City of Albuquerque

**RE: Orvis Creel Repaving Project Grading and Drainage Plan (H-16/D7)
Engineer's Stamp Dated May 23, 2003**

**RE: Orvis Creel Repaving Project Grading and Drainage Plan (H-16/D7)
Engineer's Stamp Dated May 2, 2003**

GRADING AND DRAINAGE PLAN
ORVIS CREEL OFFICE COMPLEX
LOT 4, JONES INDUSTRIAL TRACT
ALBUQUERQUE, BERNALILLO COUNTY, NEW MEXICO

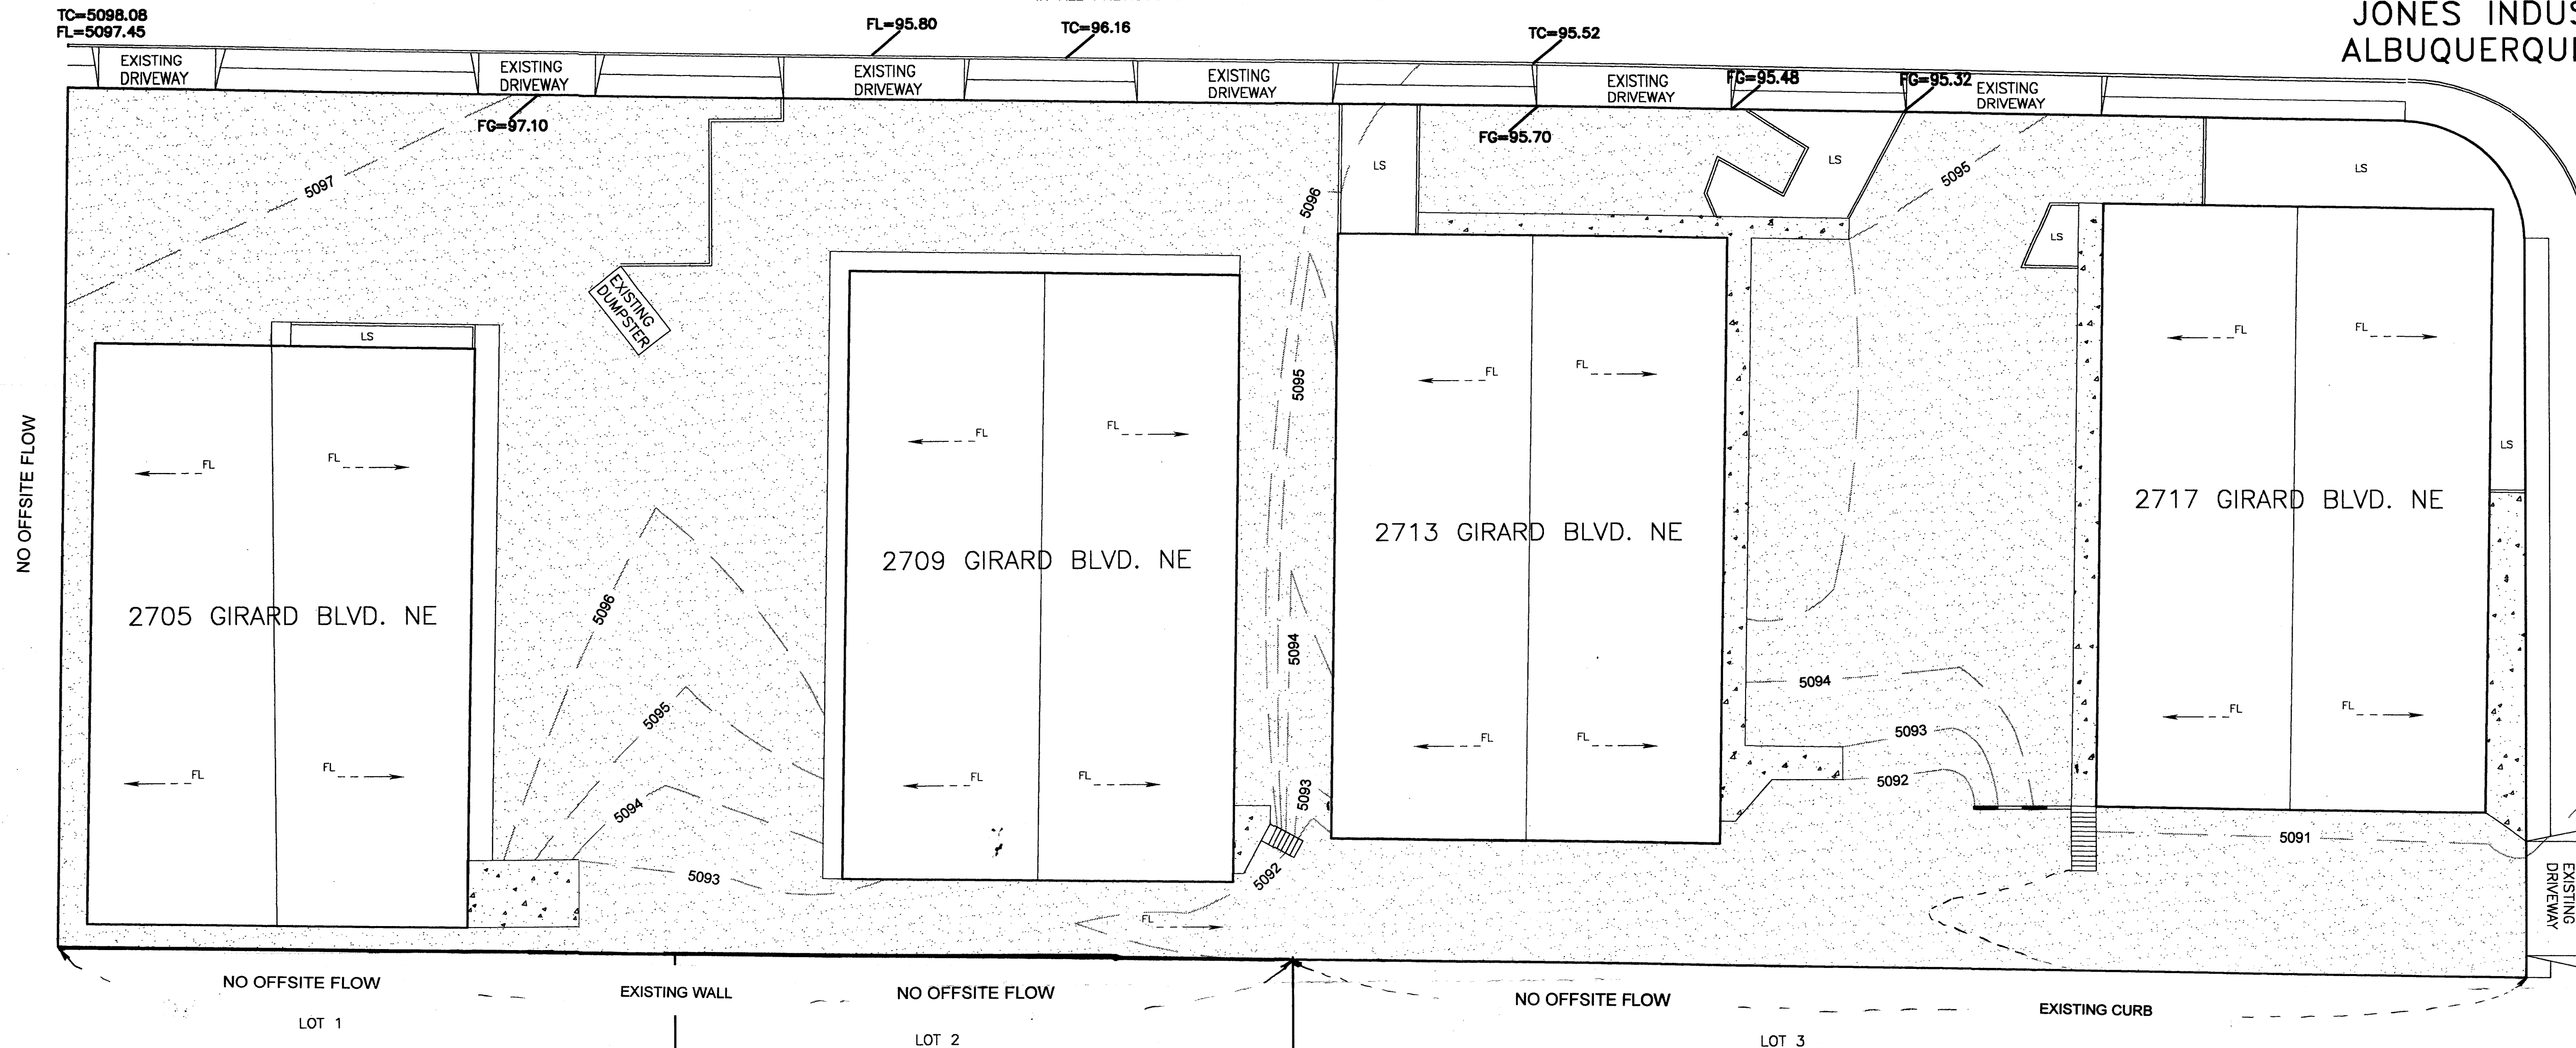
1. Please address offsite flows.
2. Will a retaining wall be needed along western property line?
3. Please show elevations on existing contour lines.
4. Please show proposed elevations.
